Non material amendment following BE/97/21/PL for changes to fenestration and change to external wall finishes (now all render).

Springfields Chichester Road Bersted PO21 5EE

Please note that the proposed drawing No 3105/ADI Rev PLI dated 16/03/22 replaces listed below originally approved drawings:

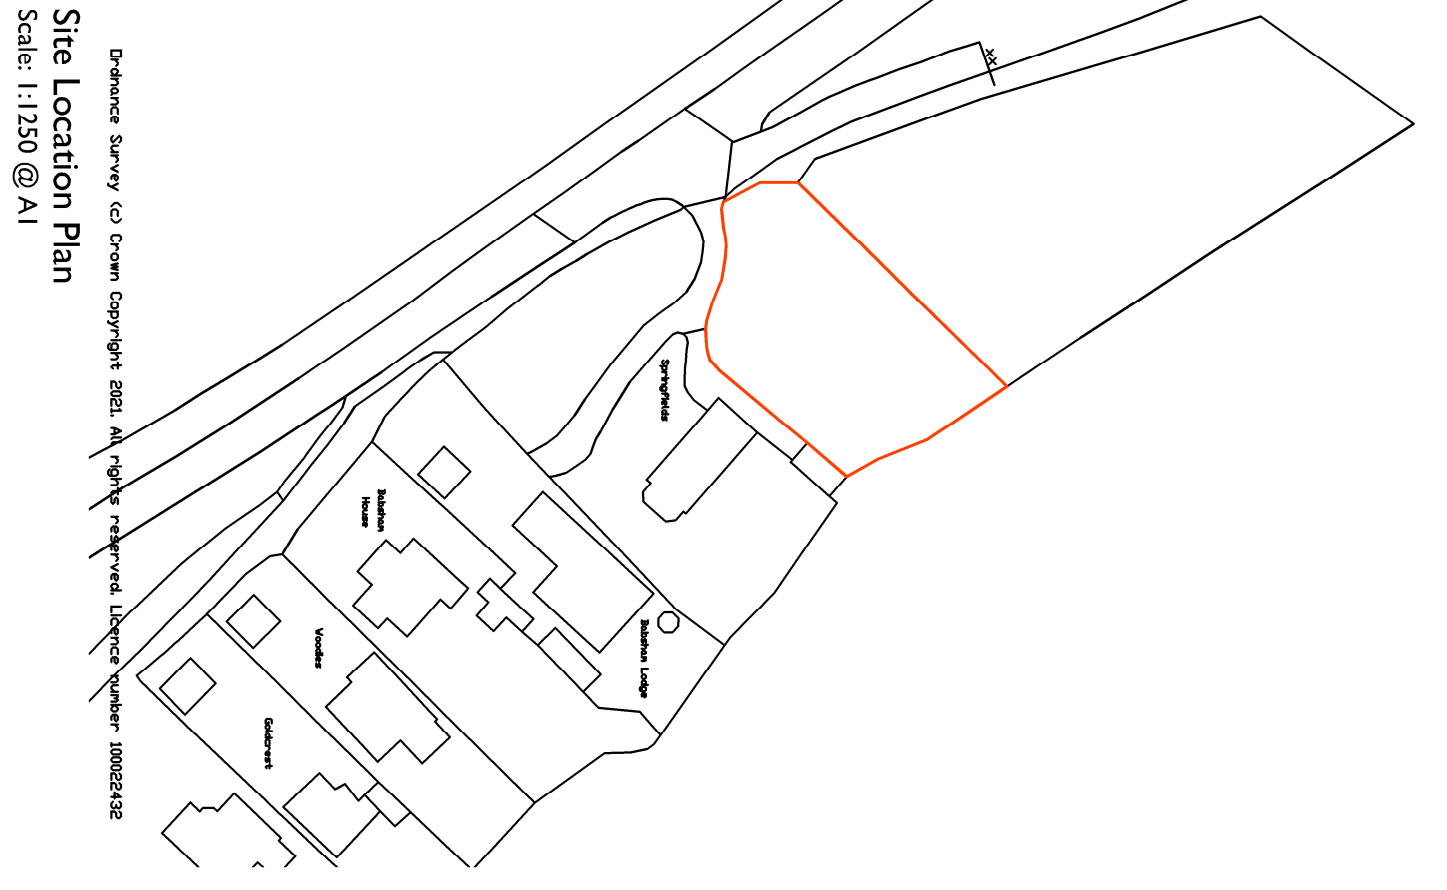
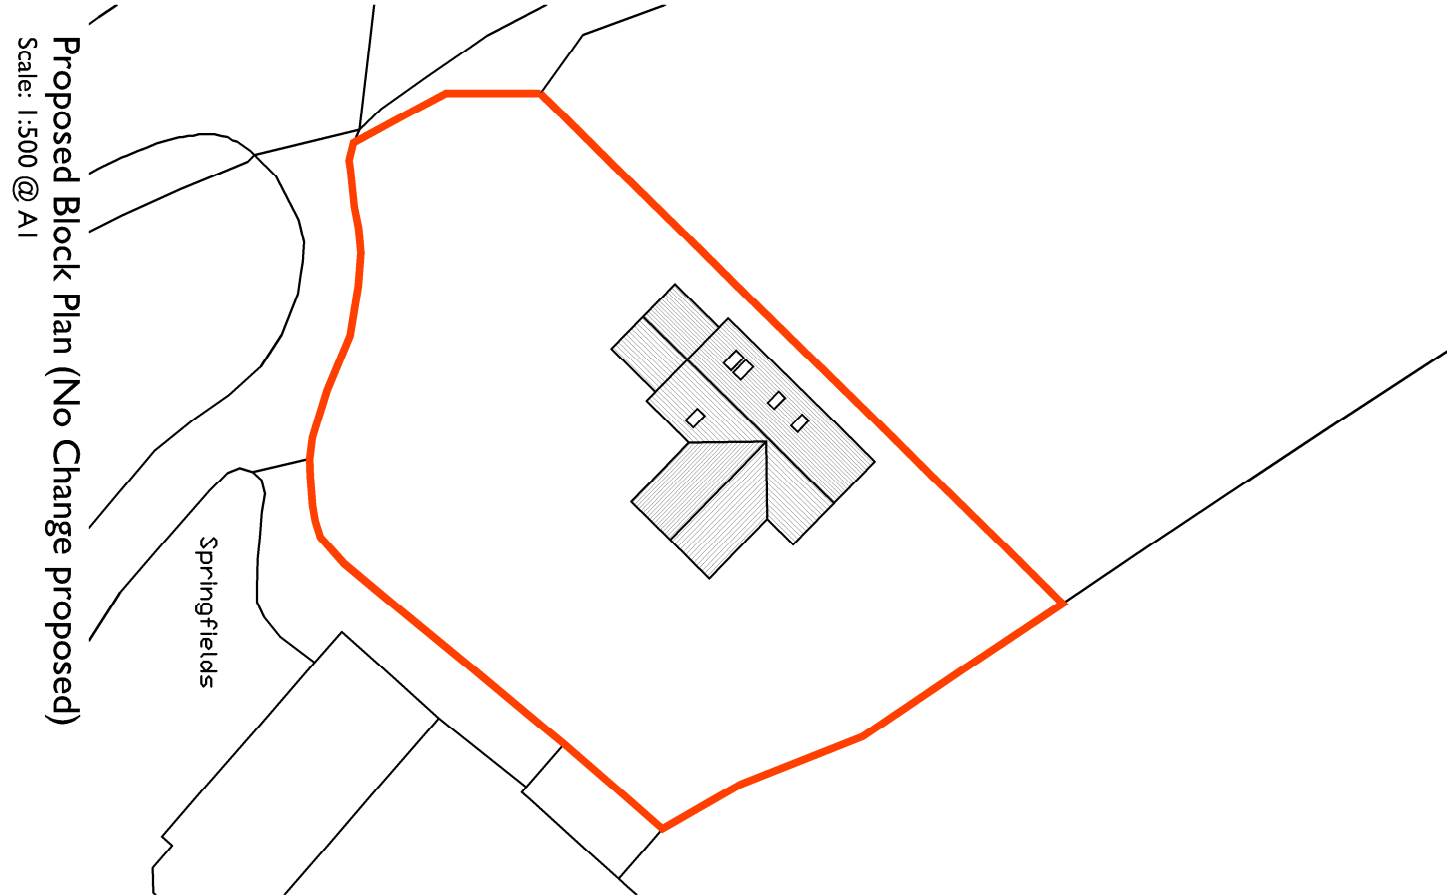
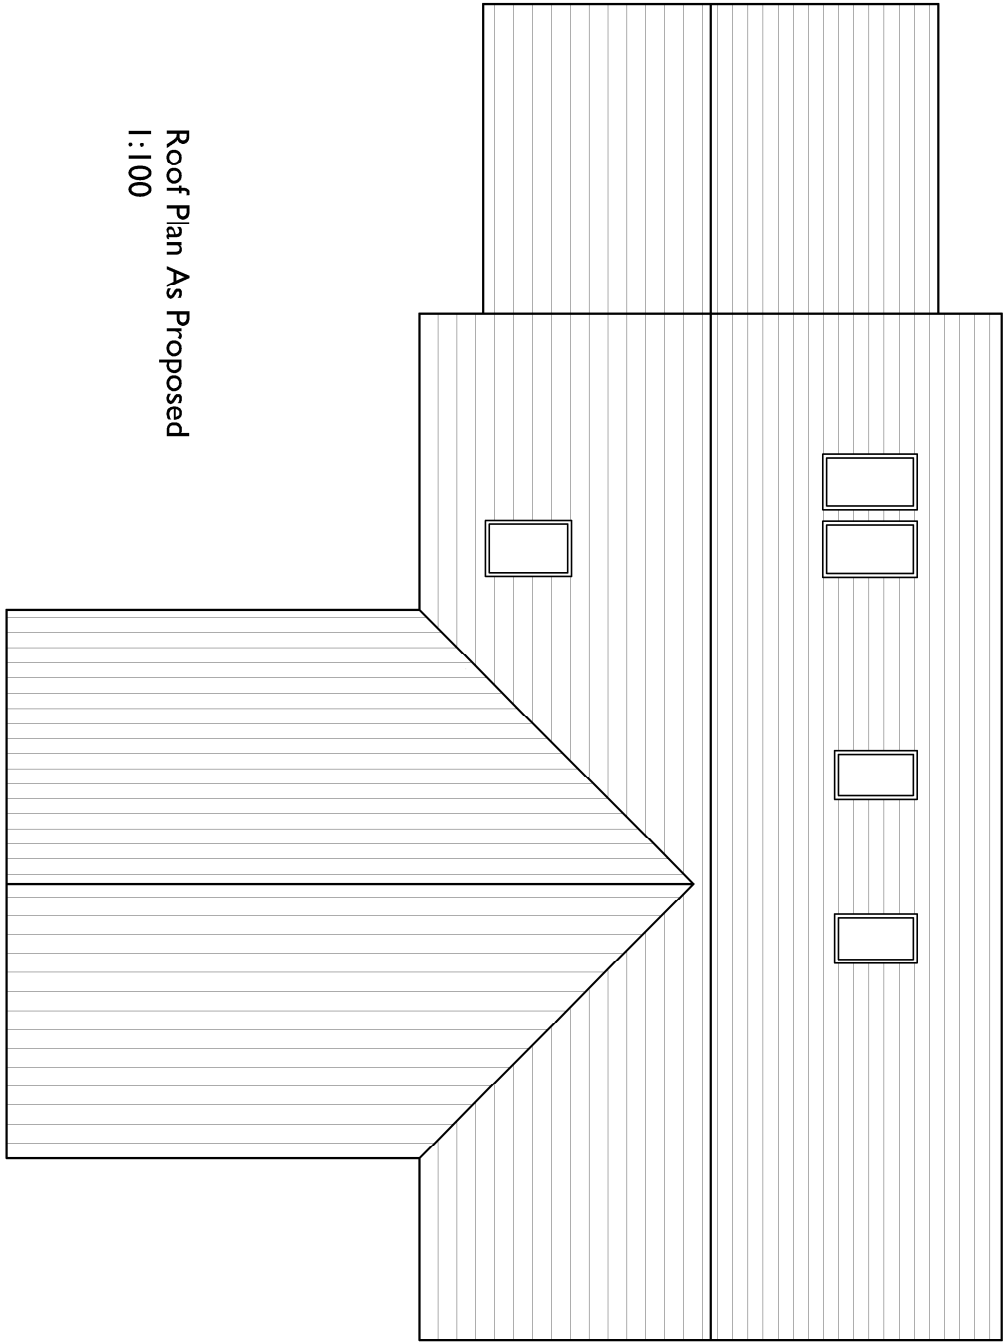
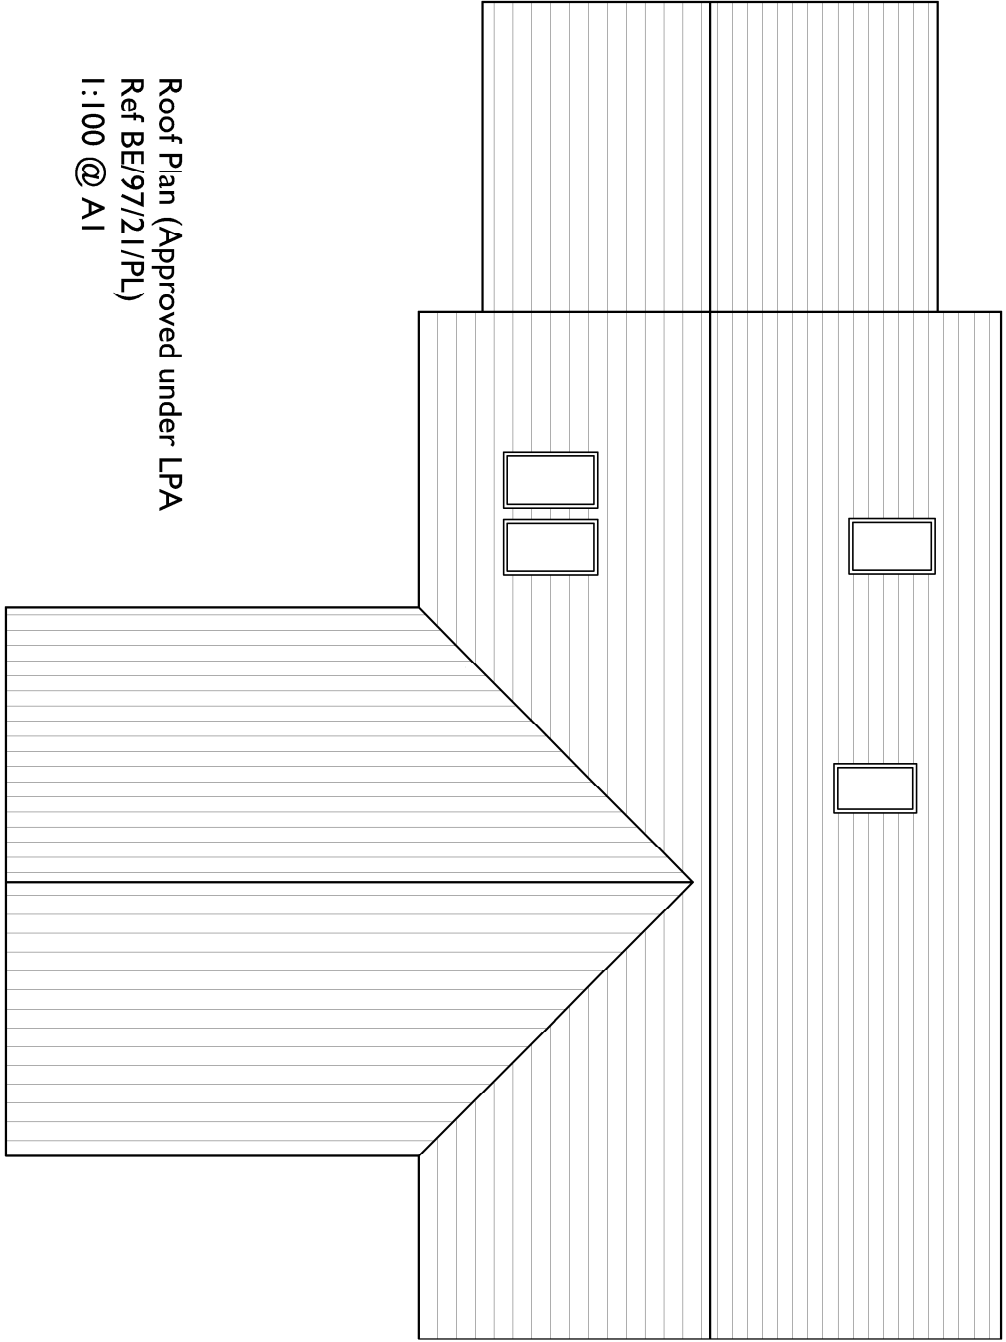
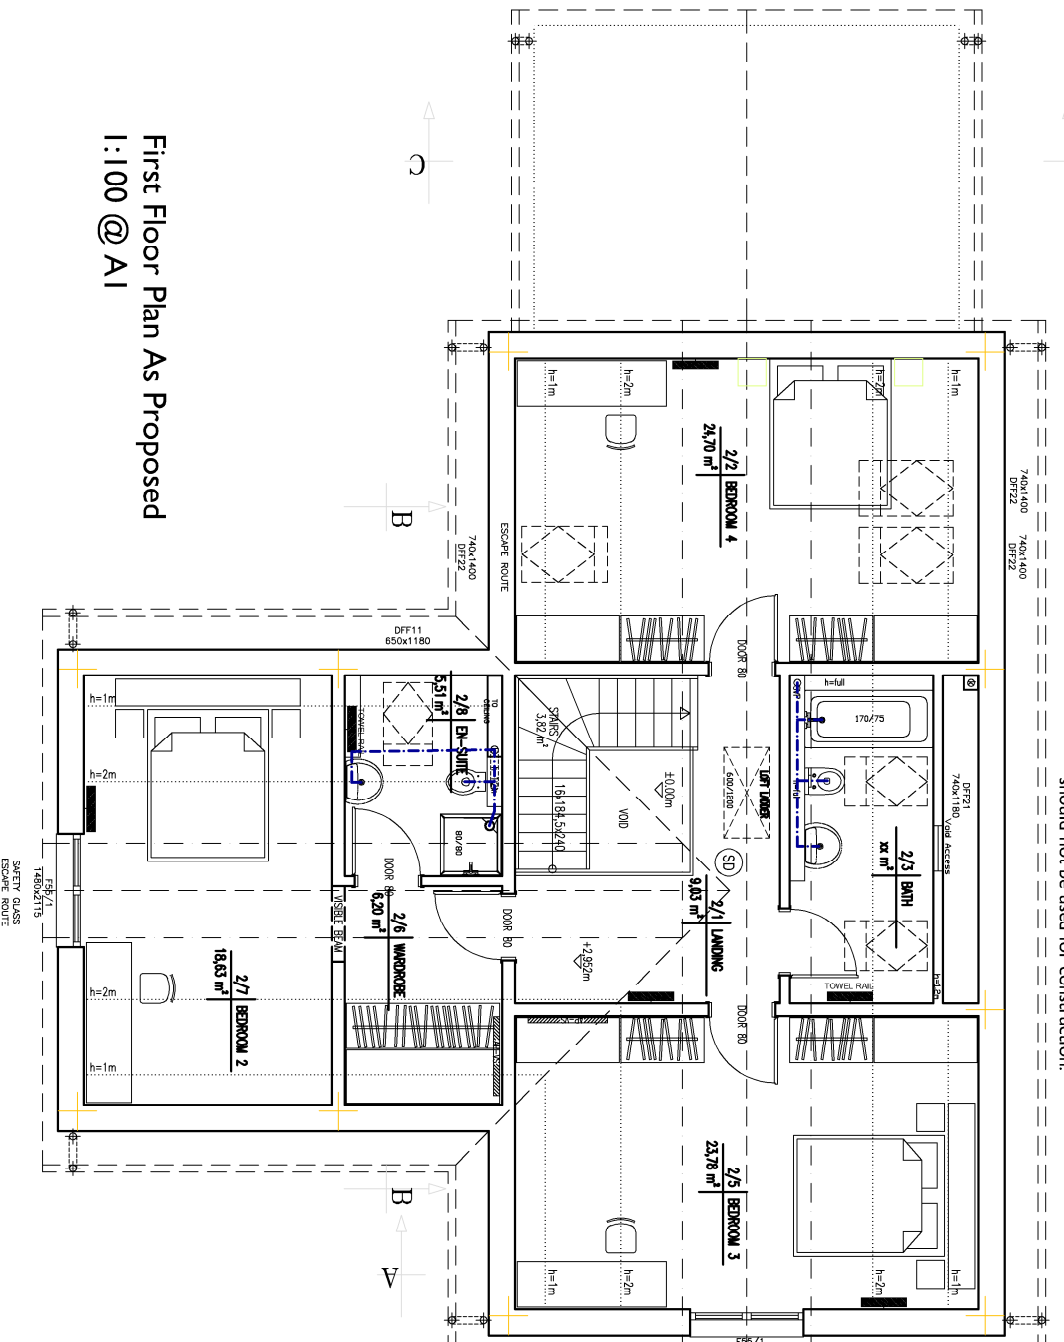
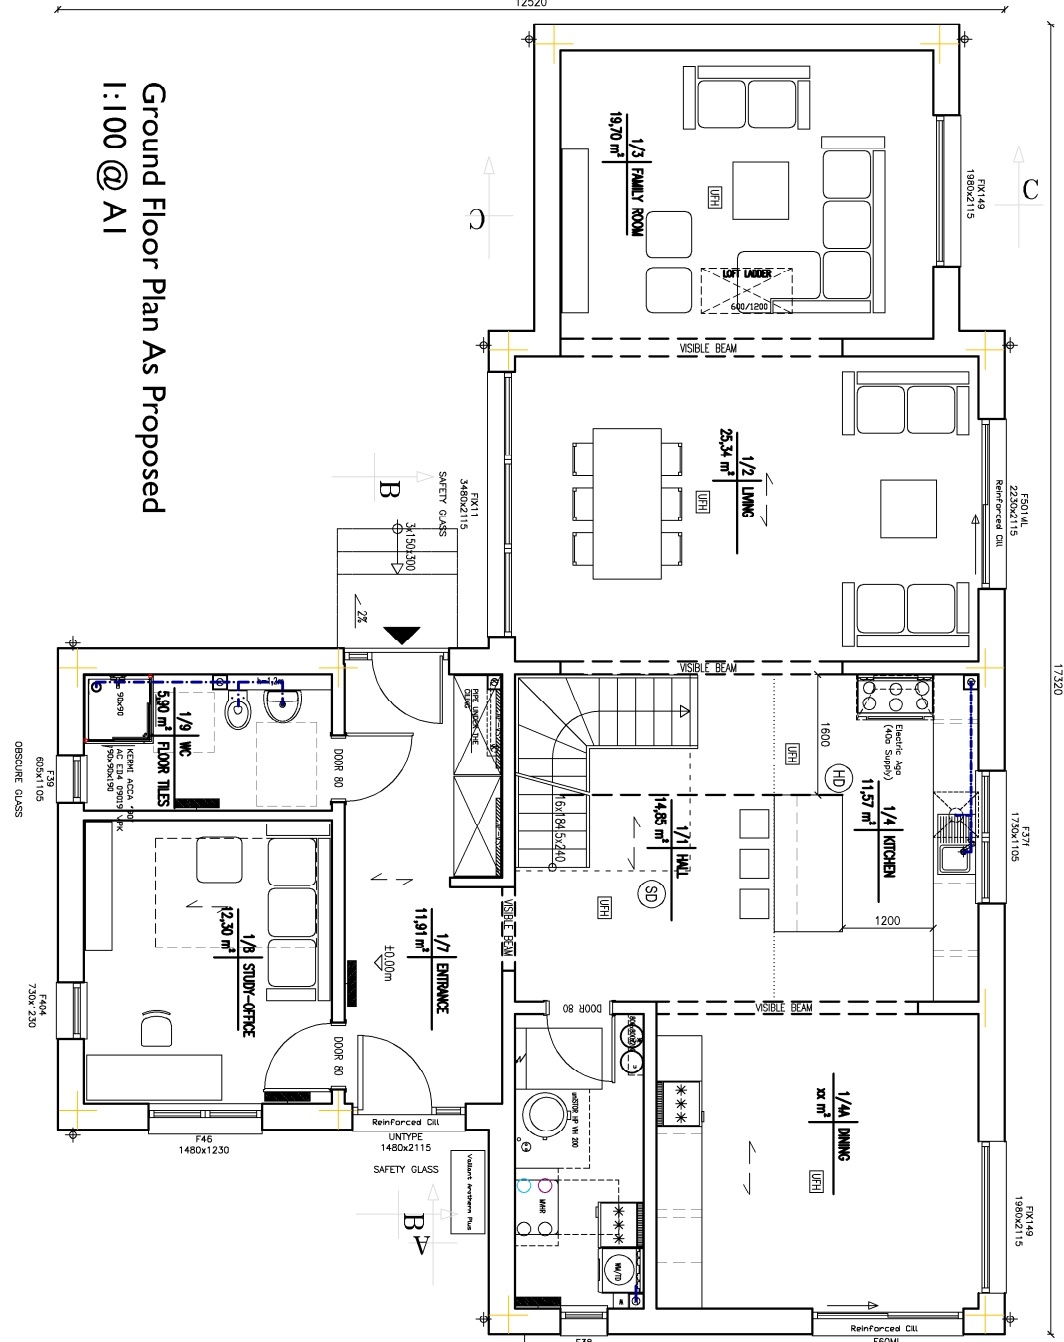
It is accepted that the proposed external cladding to parts of the walls on the south-western and south-eastern elevation would be replaced with painted render. The changes to approved fenestration are proposed as well: A triple French window on the projection of south-western elevation and a narrow French window of the main building would be removed. Two narrow French windows of the south-eastern elevation would be removed and one narrow and one wide French windows of the front projection would be replaced with two small windows. One of two proposed roof lights would be removed and the remaining would be slightly pushed down within the roof plane. A triple French window of the north-western elevation would be

replaced with a double French window, small window would be replaced with a large French window and French windows (openable) would be replaced with another non openable large French window. The approved window in the middle of north-western elevation would be replaced with a different style of window of the same size. Four roof-lights are proposed on the north-western roof plane instead of two approved. Two double French doors of the north-eastern elevation would be replaced with one French door with side narrow window and double French window. One of two small windows would be replaced with larger casement window also position of opening would be changed.

Given the dwelling would be sited far enough away from neighbouring properties all openings, subject to this application are at the ground floor except of roof lights. The north-western roof plane where further two roof lights are proposed is facing to the open fields.
